DOC19/73347-2

Dargues Gold Mine Response to submissions, Modification 4 MP10_0054

As requested, we have reviewed Dargues Reef Gold Mine Response to Submissions and advise the following:

|  | 1101 | — Crossing 2 |

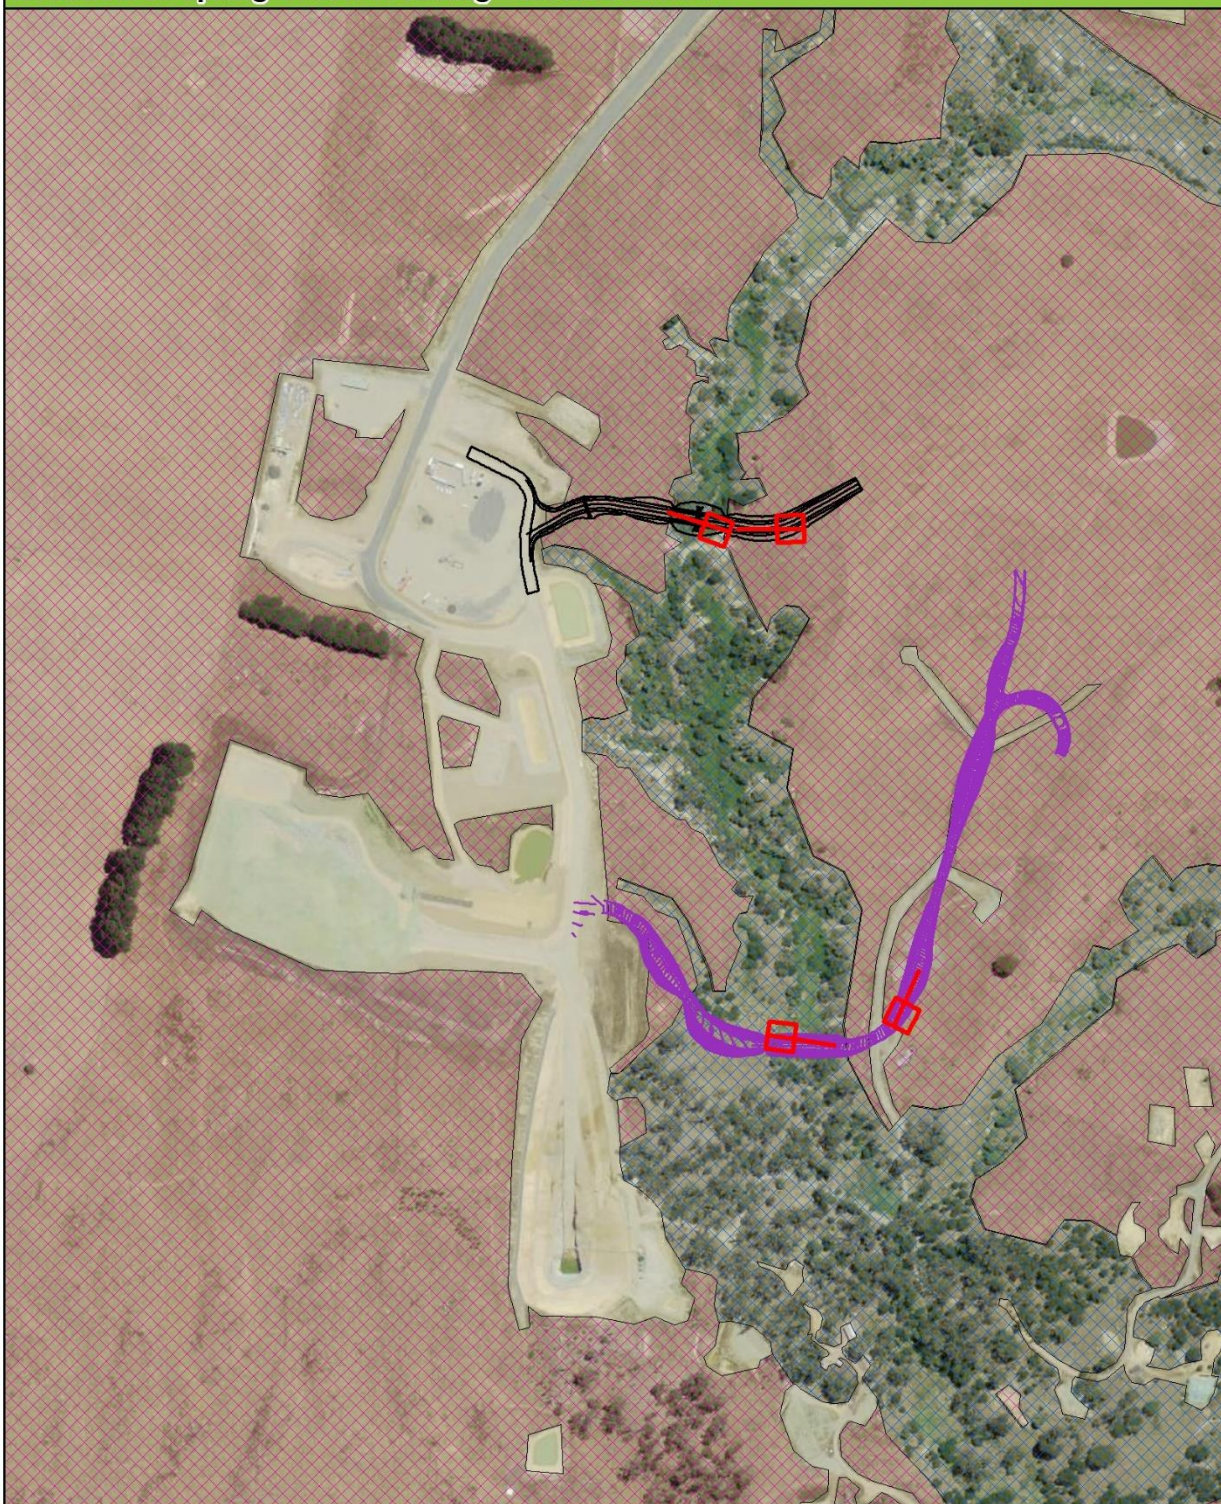
1. A vegetation integrity score (calculated using section 5.4 of the Biodiversity Assessment Method) for both crossings. We would expect that when comparing the two scores, it would clearly demonstrate that the new crossing would have a lower VIS than the approved crossing, and therefore will not require a Biodiversity Assessment Report
2. A map (developed using section 5.3.1 of the BAM) which clearly shows the vegetation zones and size of the clearing area at both crossing sites.
